ADDENDUM PLANNING BOARD REPORT PORTLAND, MAINE

Residential townhouse - 6 unit condominium
133 York Street
Level III Site Plan and Subdivision
Project ID 2013-187
133 York, LLC, Applicant

Submitted to: Portland Planning Board Public Hearing Date: January 28 th , 2014	Prepared by: Jean Fraser, Planner Date: January 24 th , 2014 Addendum to Planning Board Report # 50-13
--	--

EROSION CONTROL AND LANDSCAPE PLAN

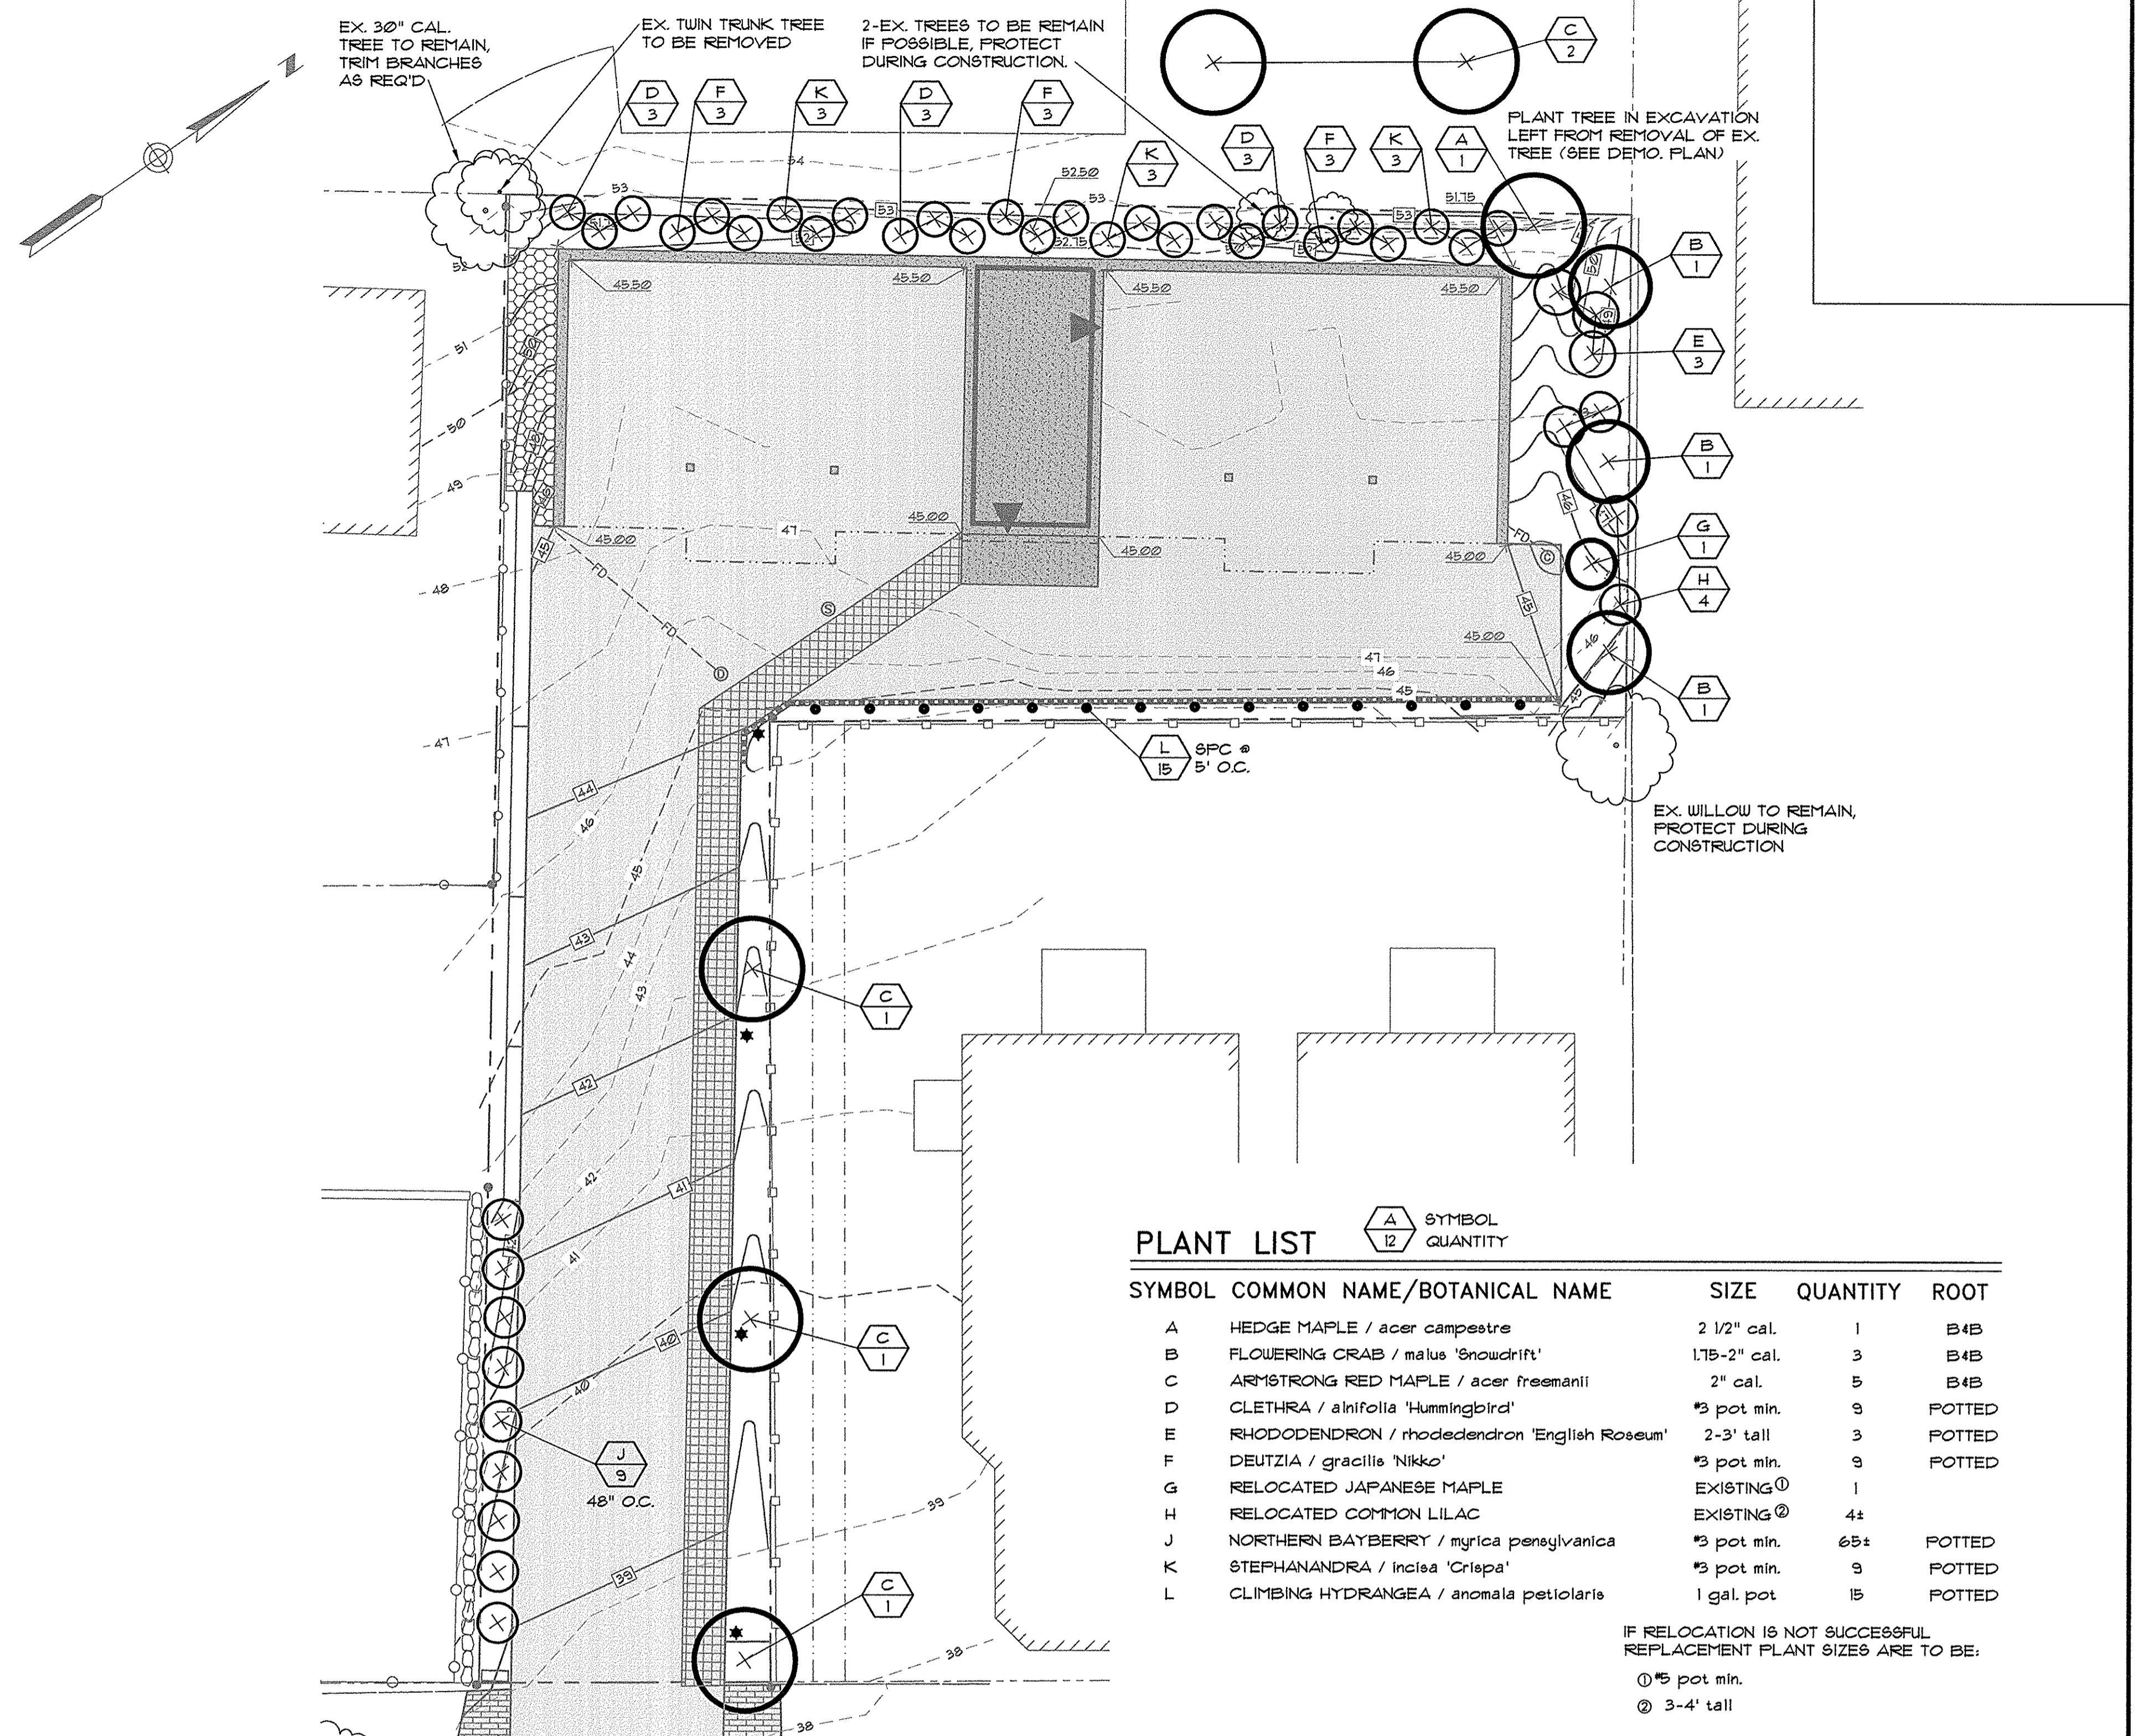
Update: The revised plans do not list the increased pot sizes for the hydrangea as recommended by staff (see Jeff Tarling comments in Attachment 2, which were also noted in Mr Tarling's previous comments) nor clarified re the fencing on the south boundary, so a similar condition has been included in the Motion for the Board to consider.

- ii. That the applicant shall submit a revised Site Plan, Utility Plan and Landscape Plan that address the 1.23.2014 City Arborist comments in respect of planting materials, and include documentation of fencing details on the south and west boundaries and utility modifications on and near the north boundary, for review and approval by the Planning Authority, Department of Public Services and City Arborist prior to the issuance of a building permit; and

Drawing file: Final Plans / Plan 2 - Subdivision Recording Plat.pdf

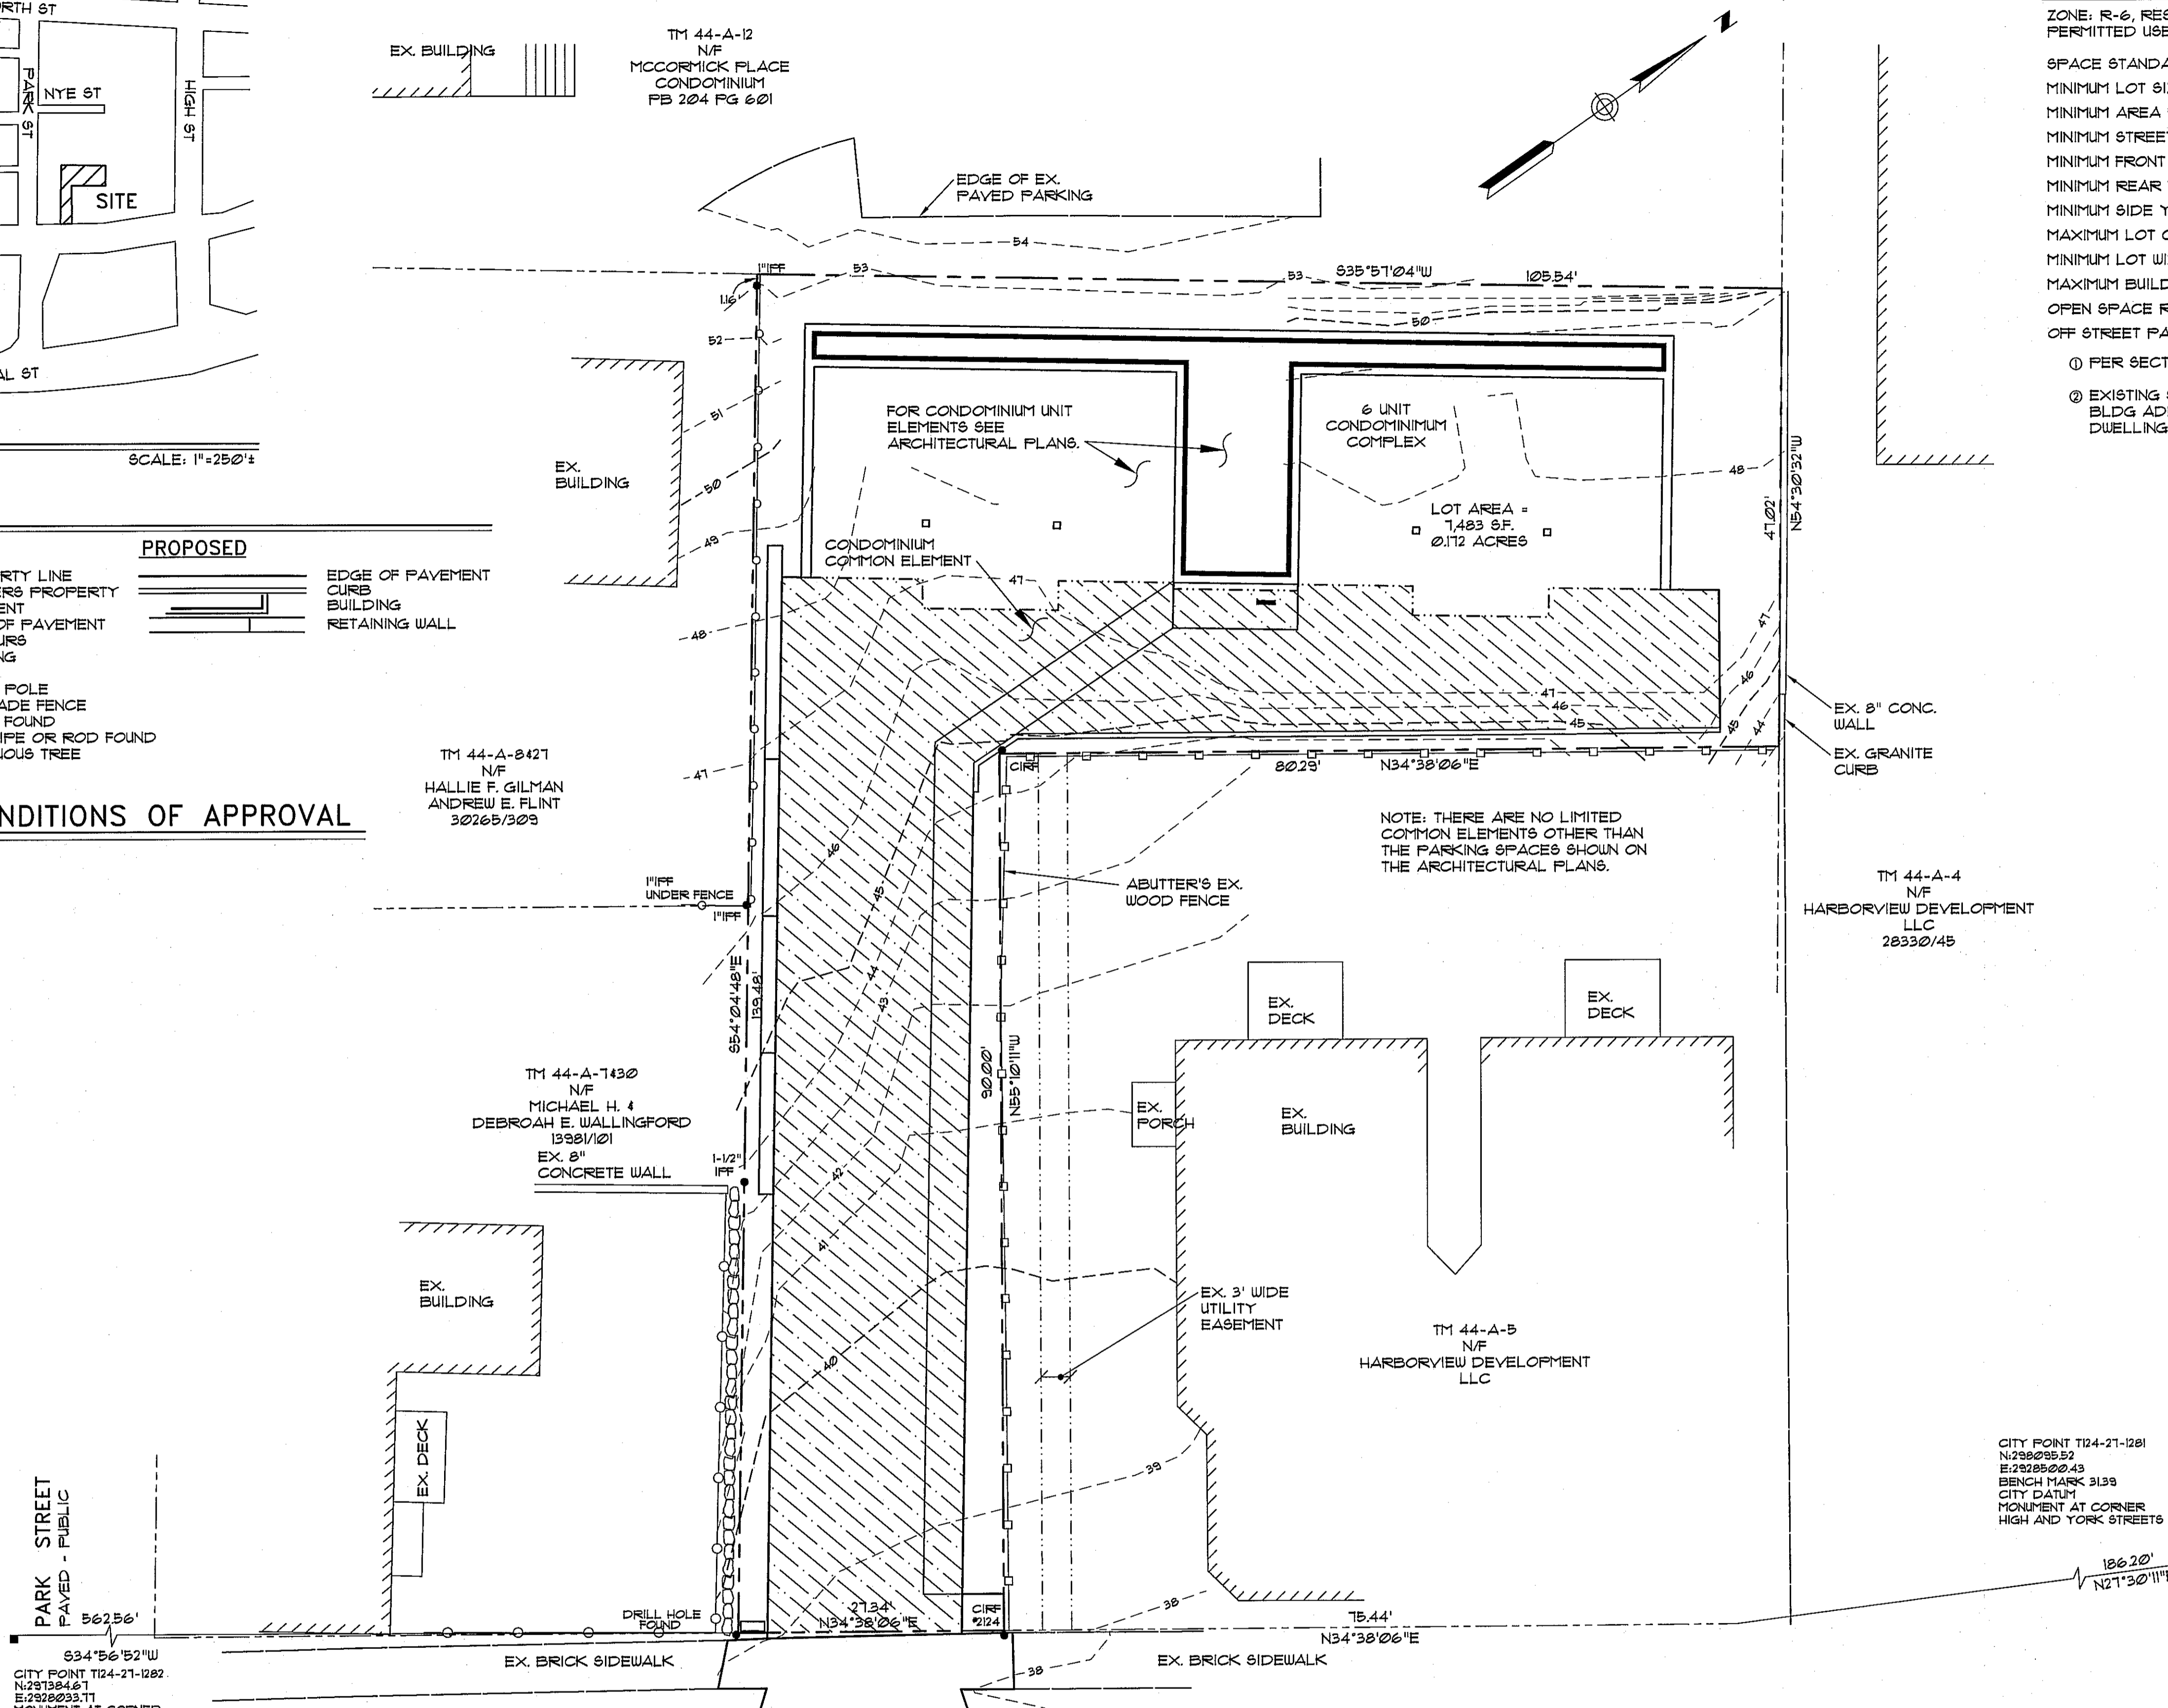
Update: The applicant has submitted an amended draft Subdivision Plat (Plan P2) and revised condominium association documents (Attachment B). Staff have requested that key issues and features of the proposal be identified and noted on the plat and in the condo documents eg snow removal, tree preservation and stormwater maintenance responsibilities. These are not mentioned in the documents and the plat as drafted shows these by reference to other plans and documents but does not specify the limitations directly. As explained in the comments from the Associate Corporation Counsel (Attachment 5), where there are important limitations that would apply in the long term these should be explicitly stated. The two conditions still apply but have been reworded.

Update: The applicant has noted the tree preservation requirements on the site plan but a condition is still required to identify which trees are to be preserved on the plat and to ensure that the plat and the Association documents specify the requirements in more detail.

- i. That the Subdivision Plat shall be finalized to the satisfaction of the Planning Authority, Corporation Counsel, and Department of Public Services and include detailed references to easements, snow removal, tree preservation, stormwater system maintenance, relevant conditions, and addressing the comments of the Associate Corporation Counsel dated 1.23.2014; and

- iv. That the applicant shall ensure that tree preservation/protection measures are undertaken in accordance with the comments of the City Arborist dated 9.6.2013 and 11.1.2013, and that the Condominium Association documents shall include responsibilities for ongoing tree preservation measures; and
